**WELWYN HATFIELD BOROUGH COUNCIL  
EXECUTIVE DIRECTOR - PLANNING, PUBLIC PROTECTION AND GOVERNANCE**

**DELEGATED APPLICATION**

**Application No:** 6/2018/1218/HOUSE  
**Location:** 31 Selwyn Crescent Hatfield AL10 9NL  
**Proposal:** Erection of a first floor side and single storey rear extension  
**Officer:** Mrs Kerrie Charles

**Recommendation:** Granted

TITLE:-
Plans and Elevations
as Proposed

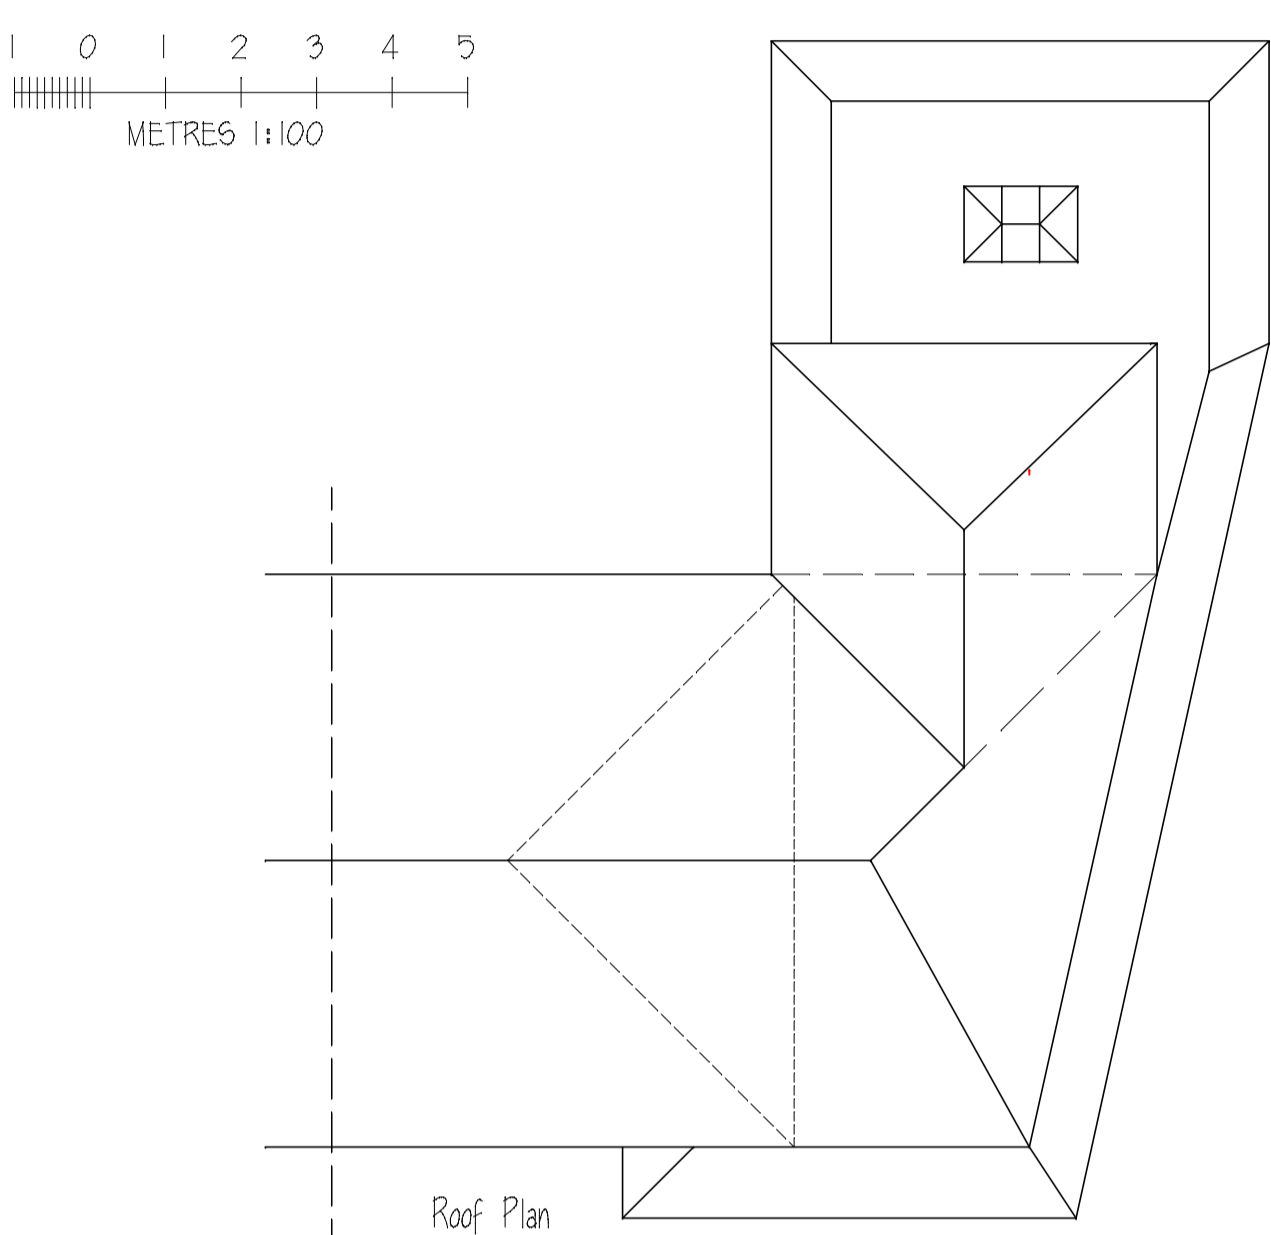
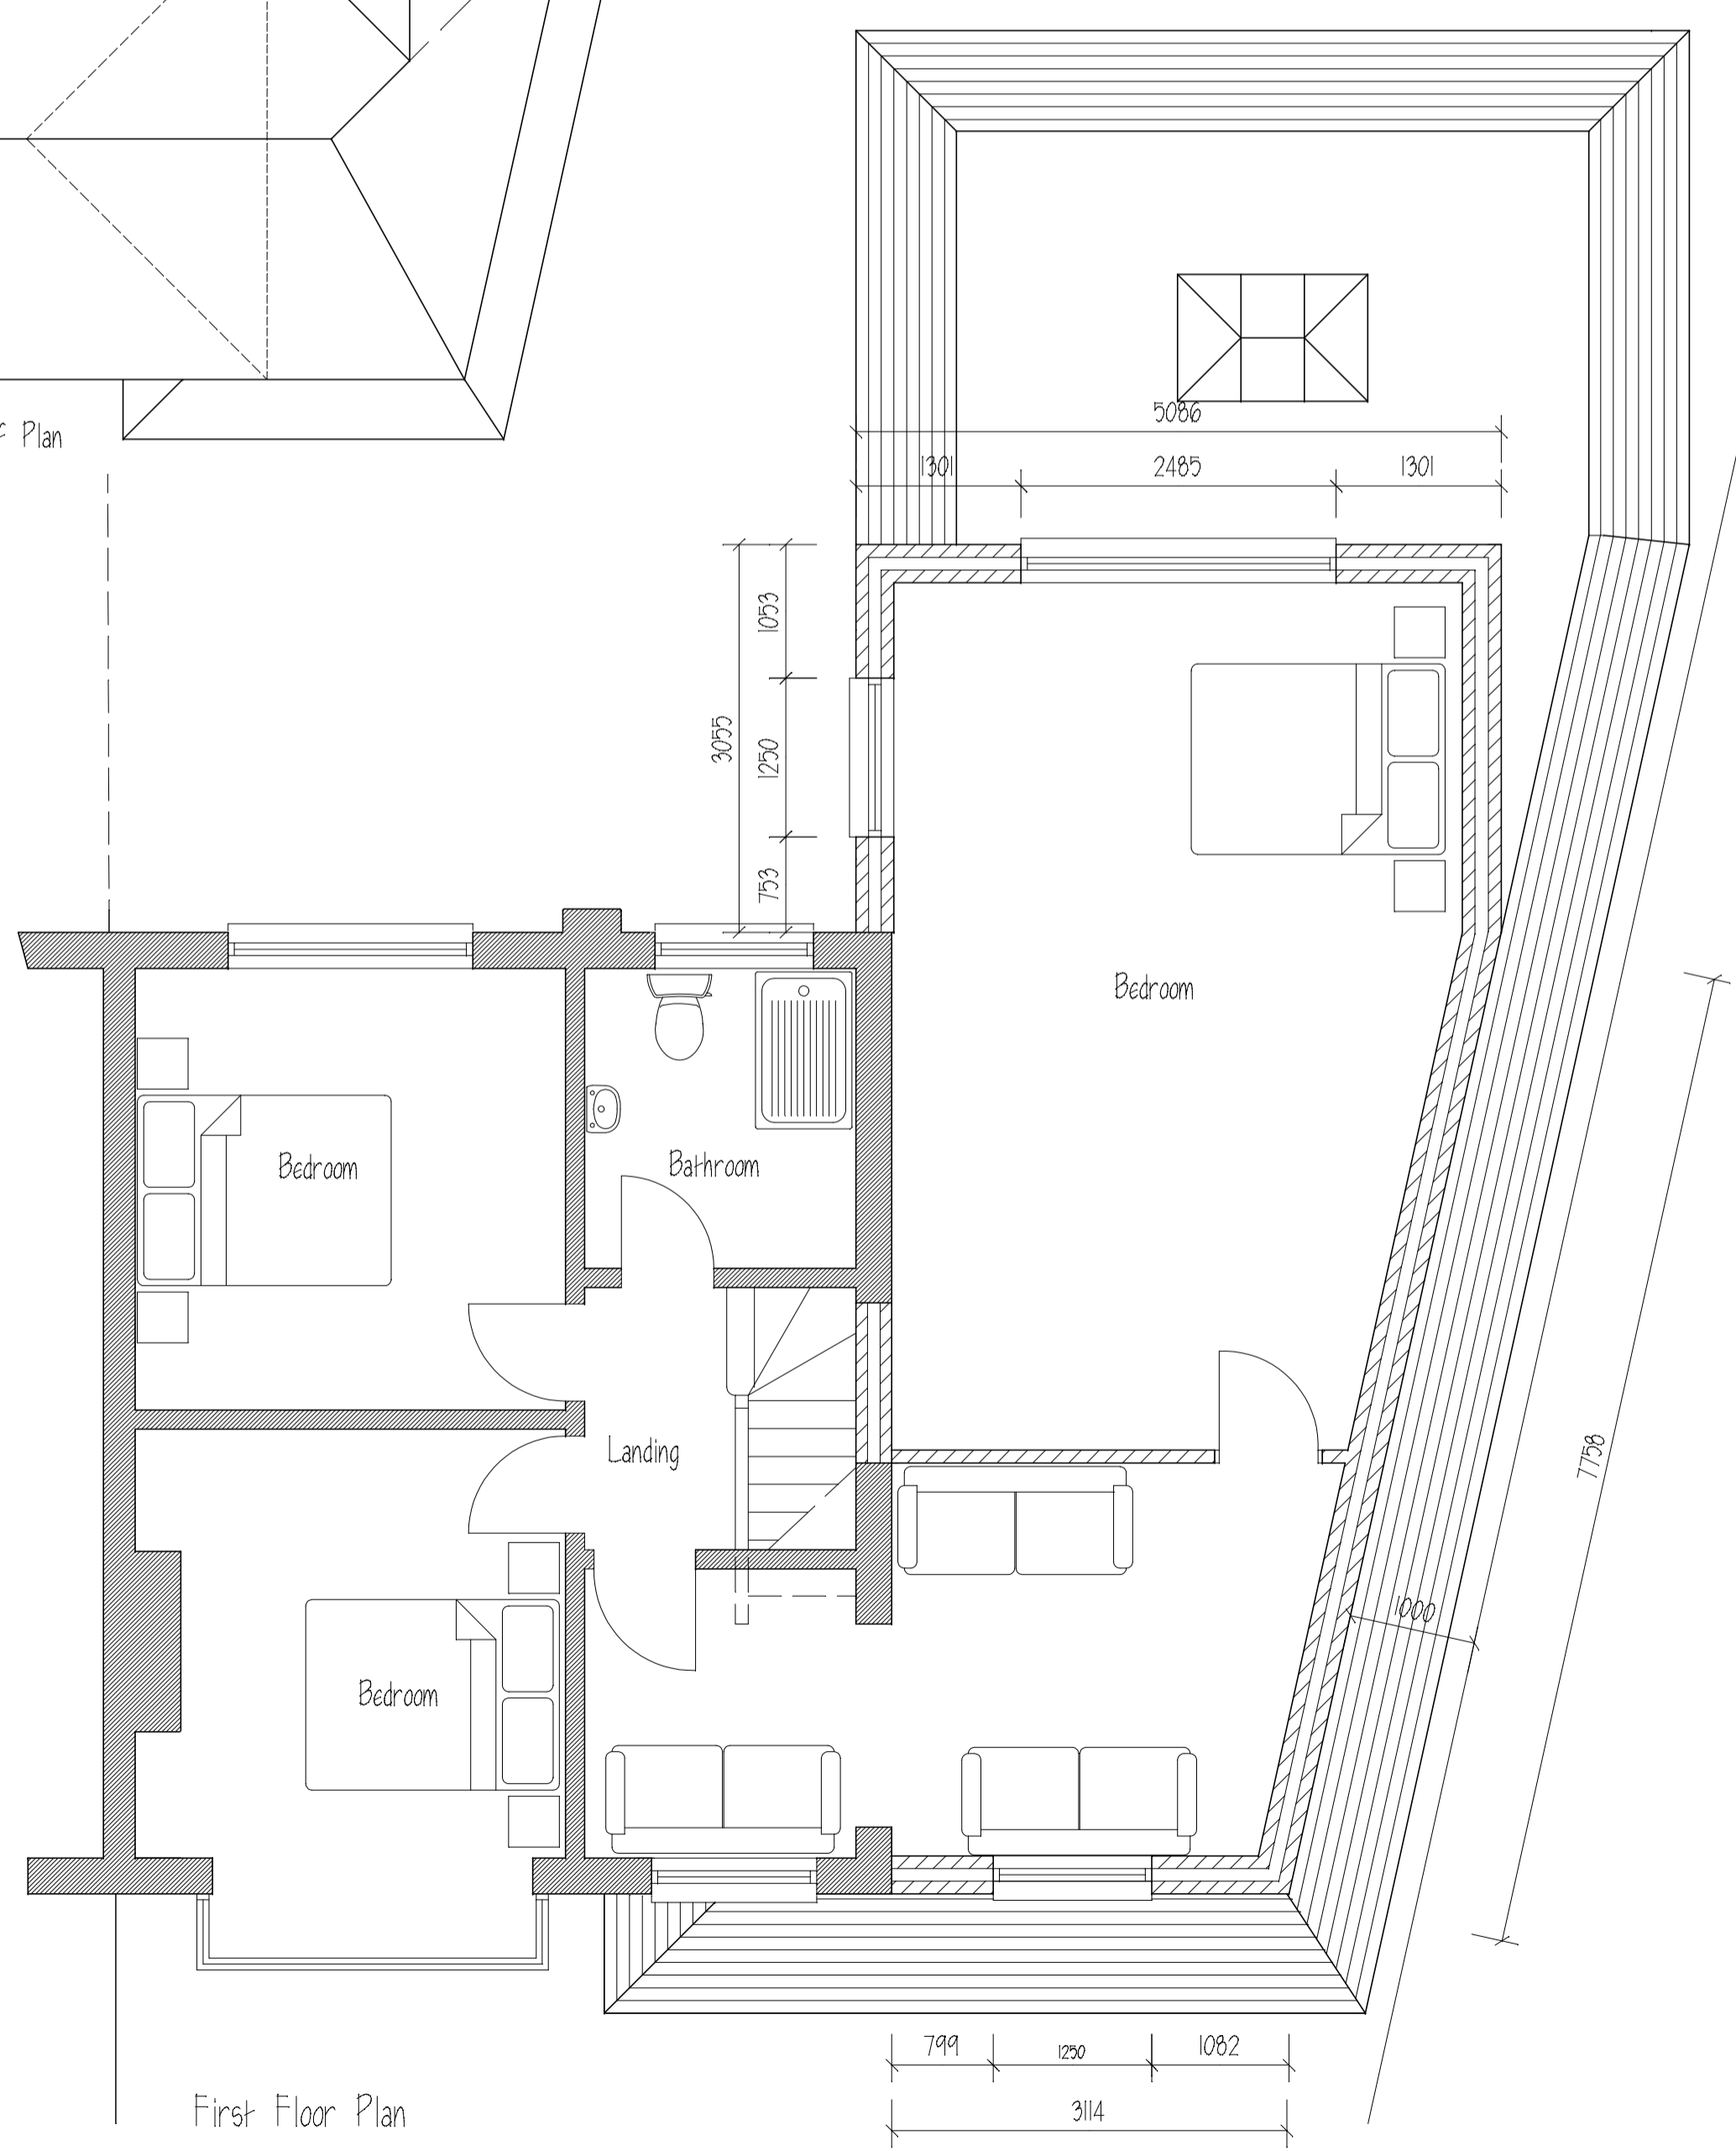
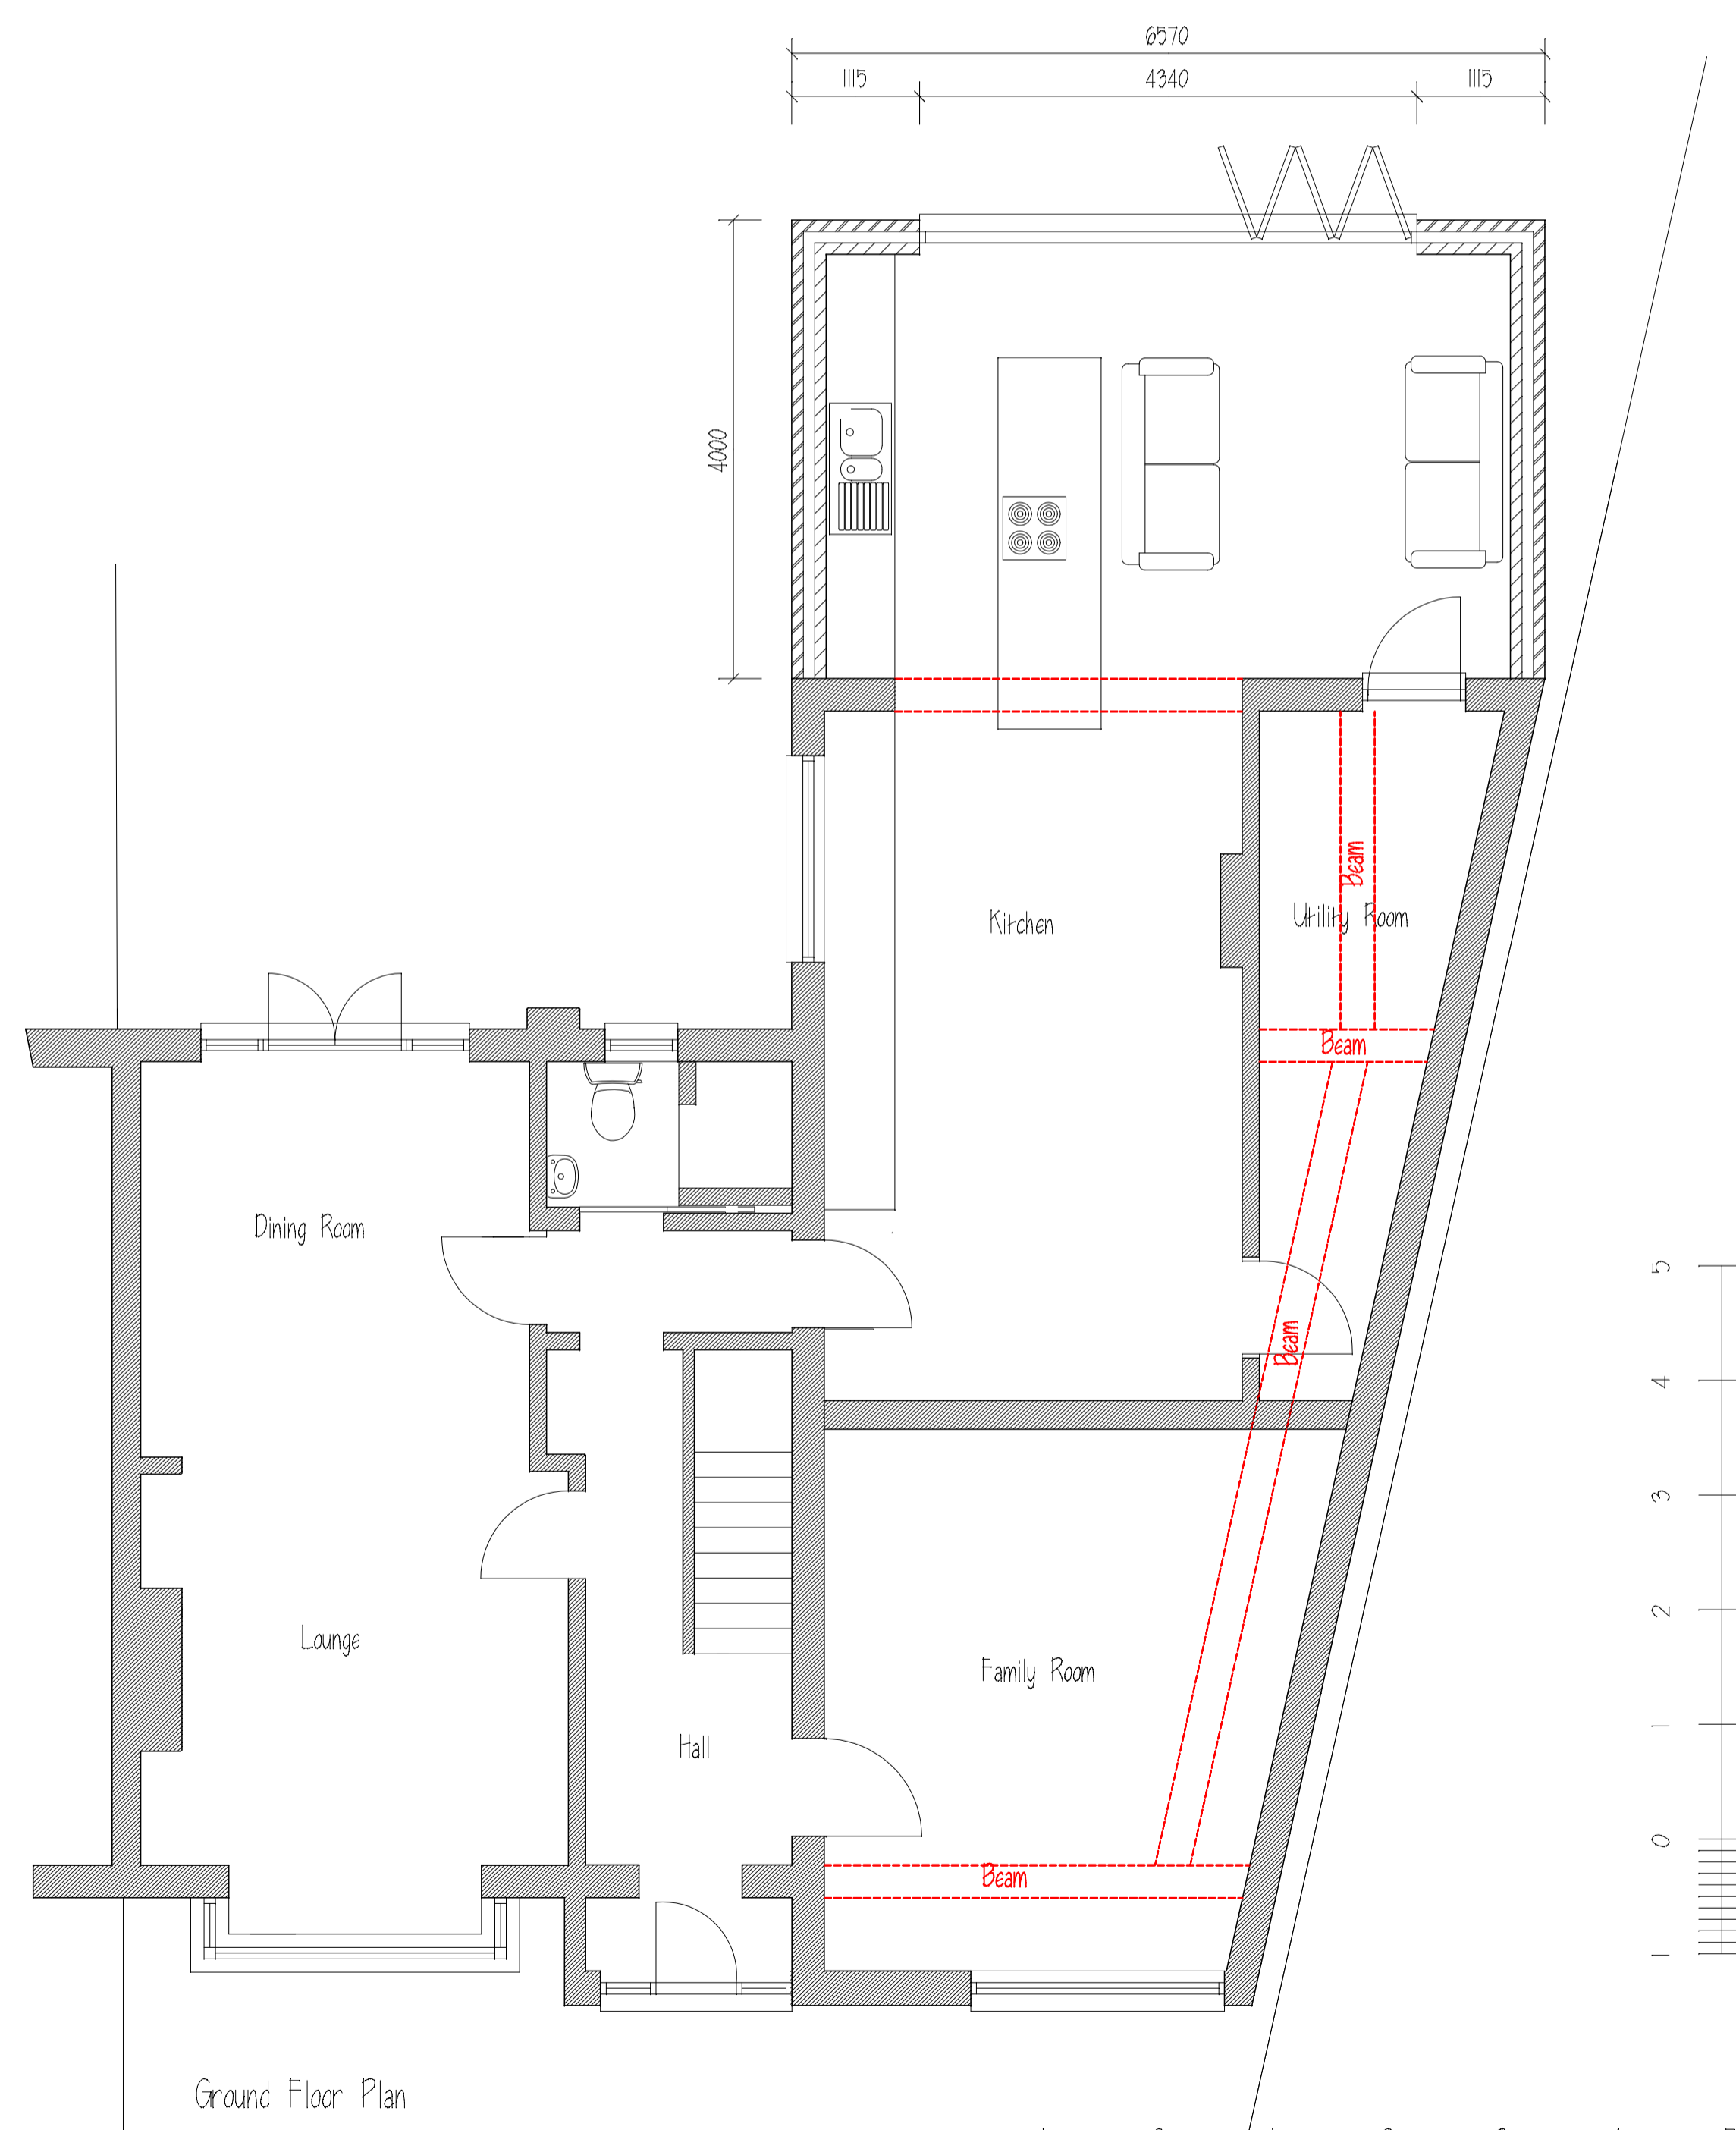
<b>Main Issues</b>			
<b>Design (form, size, scale, siting) and Character (appearance within the streetscene)</b>	<p>This proposal follows refused planning applications 6/2018/0225/HOUSE with the main difference being a change to the design of the roof, whereby a hipped roof is proposed sloping away from the flank elevation of the building in place of a gable ended roof. This arrangement is considered to be more sympathetic to the character of the application dwelling and would reflect the existing extensions to neighbouring properties.</p> <p>A number of neighbouring properties within the immediate vicinity feature two storey side extensions of various designs, including Nos.20, 24, 26, 28, 29, 31, 33, 35, 47 and 51 Selwyn Crescent and also several other properties within the wider area. Whilst the proposal is still for a large extension, having regard to other extensions on the surrounding area together with the redesign of the roof, it would not appear unduly conspicuous or dominant within the streetscene.</p> <p>In regards to the width of the proposed extension, the submitted application drawings show that a minimum of 1m separation distance would be maintained between the first floor of the extension and the flank site boundary. This level of separation is considered to be in keeping with existing spacing within the streetscene and would not result in an overly cramped appearance.</p> <p>Due to its position, the single storey rear extension would not be readily visible from any public vantage point and therefore would have no discernable impact on the character of the area or the visual amenity of the street scene.</p> <p>Overall, subject to a planning condition regarding matching materials, it is considered that the design of the resulting dwelling would adequately respect and relate to the character of the area. The extensions are therefore considered to be in accordance with the National Planning Policy</p>

Framework; Policies D1 and D2 of the Welwyn Hatfield District Plan 2005 and Supplementary Design Guidance 2005 (Statement of Council Policy).
<b>Impact on neighbours</b>	<p>The neighbour most likely to be affected by the proposal is No.33 Selwyn Crescent. The proposed development would extend further back beyond the adjacent property. Although the development would be within closer proximity to the common boundary, the first floor element, would not be unduly dominant or result in loss of light to this adjacent property to warrant a refusal in this regard.</p> <p>In terms of privacy, a new first floor side window serving a bedroom would be installed. This window would present views towards No. 29. As such, in the event of a grant of planning permission, it would be considered necessary and reasonable for this window to be glazed in obscure glass and have a restricted level of opening in order to maintain the levels of privacy enjoyed by the occupier(s) of No. 29. With regard to No. 33, there are no first floor windows proposed that would face to the side of this property. Additionally, window positions at the front and rear would have only oblique views towards the rear gardens of neighbouring properties and are not considered to cause an undue loss of privacy to warrant a refusal in this regard.</p> <p>This property is attached to the host dwelling. It is not considered that the proposed development being single storey would result in a detrimental impact on the residential amenity of this neighbouring occupier in terms of loss of light, appearing unduly dominant or result in an impact on privacy.</p> <p>Overall, it is considered that the living conditions of the adjoining occupiers are maintained to an acceptable level in accordance Policy D1 Welwyn Hatfield District Plan 2005 and Supplementary Design Guidance 2005</p>

3. The upper floor side window located in the western elevation facing towards No. 29 Selwyn Crescent of the extension hereby approved must be obscure-glazed and non-opening unless the parts of the window which can be opened are more than 1.7 metres above the floor of the room in which the window is installed, and shall be retained in that form thereafter.
